Arun District Council
Arun Civic Centre
Maltravers Road
Littlehampton
West Sussex BN17 5LF
Planning & Building Control General Enquiries
Tel: (01903) 737756 Fax: (01903) 730442
Dx: 57406 Littlehampton
Minicom: 01903 732765
e-mail: planning@arun.gov.uk
website: www.arun.gov.uk/planning

Application No: A/193/20/PL
Site Address: Ham Manor Cottage Ham Manor Way Angmering BN16 4JQ
Description of works: Erection of a 1 No. 3 bedroom chalet bungalow & detached garage. This site is in CiL Zone 3 and is CIL Liable as dwelling.

Thank you for your internet representation made on 14th February 2021 which has been recorded as an objection with the comments as follows:

Proposed Street Scene (Scale 1:200)

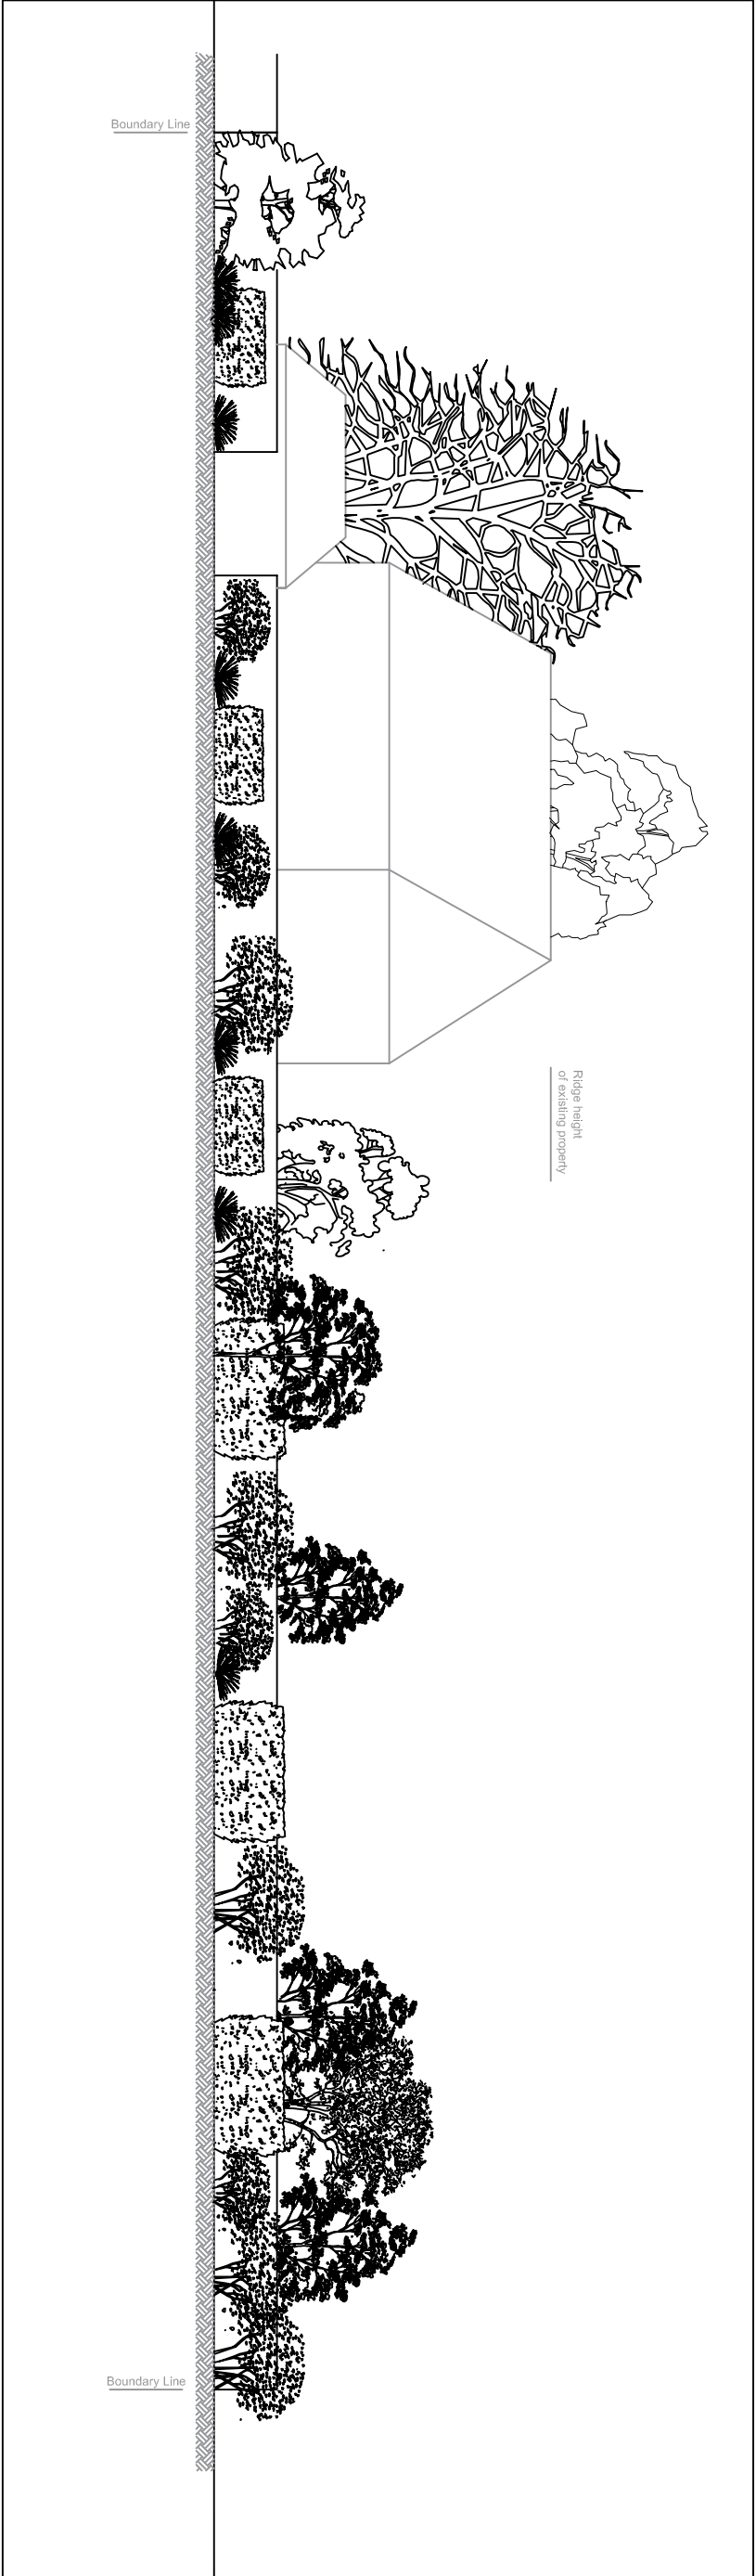
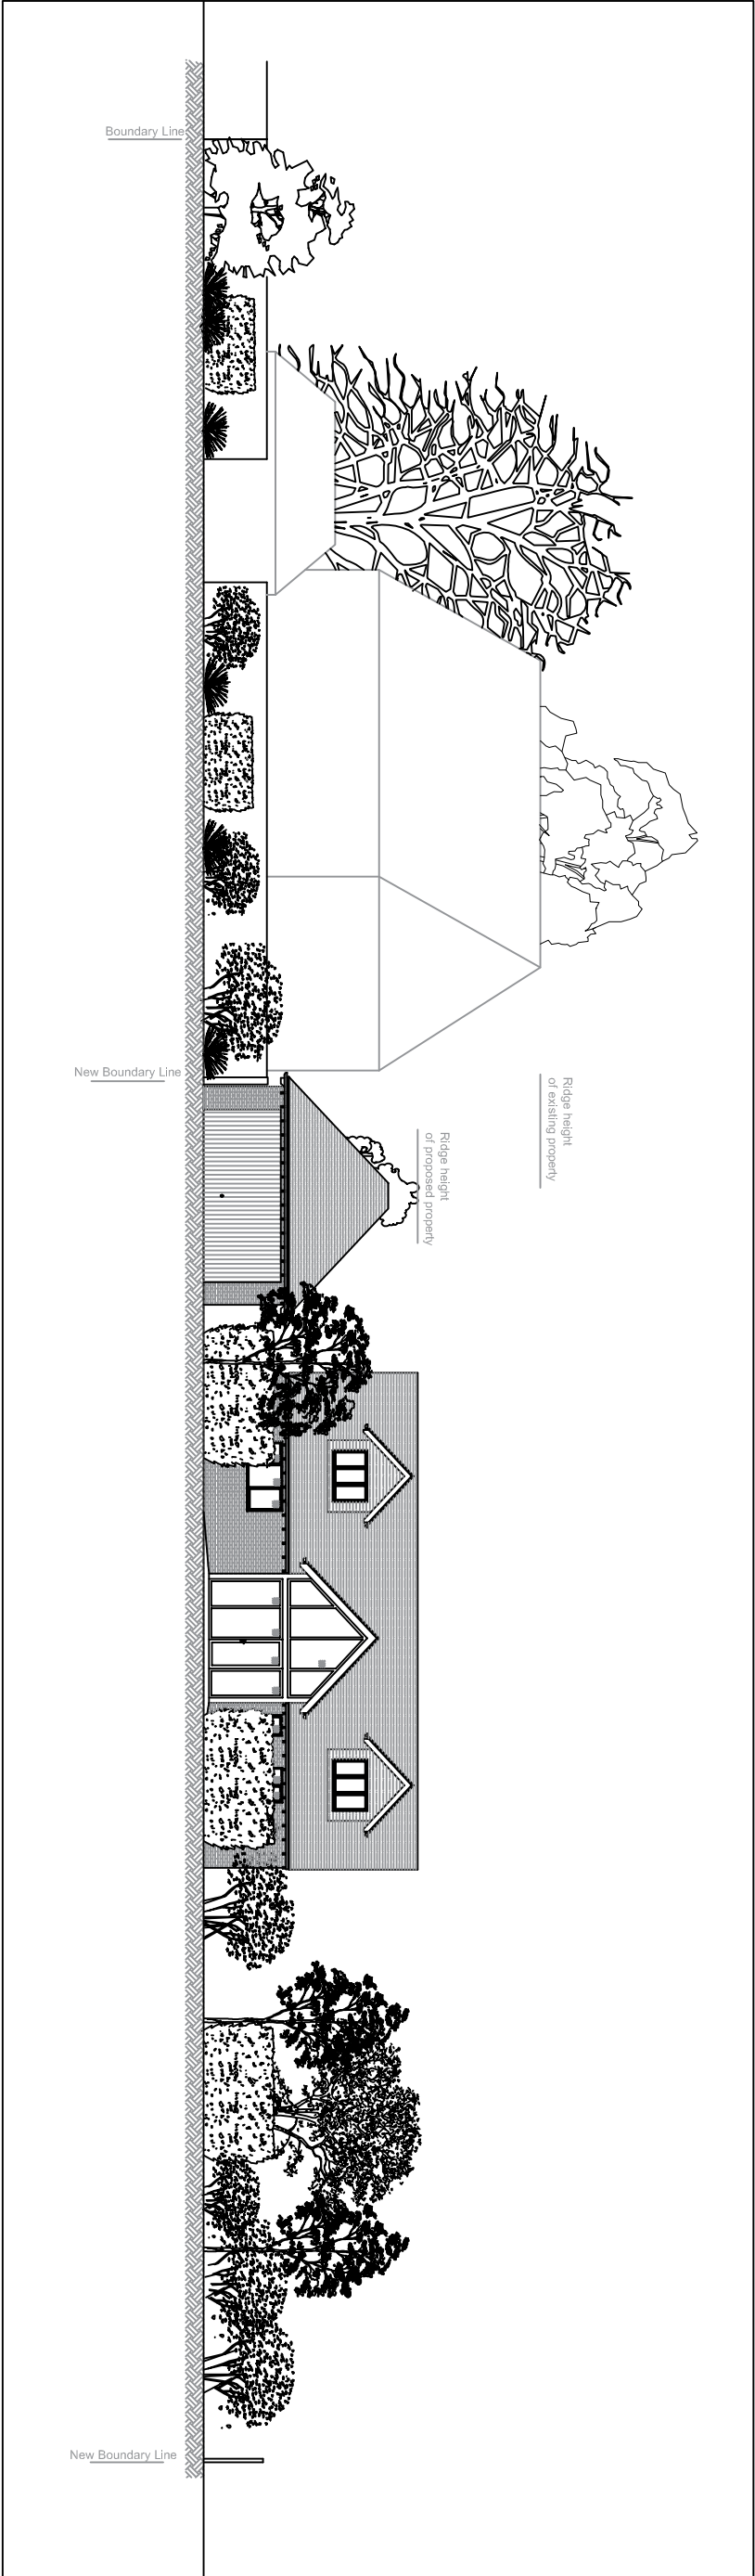
- * The proposals locate the development in front of the current building line and would consequently have an adverse impact on the street scene.
- * The plot size is too small for proposed development, and again impacts on the street scene where properties are well spaced. This will result in detriment to the character of the area.
- * There will be considerable loss of vegetation / established trees due to access arrangements resulting in negative impact on the environment.
- * Increased traffic , both long term and short term. Damage to roads not designed to support heavy building work vehicles.
- *
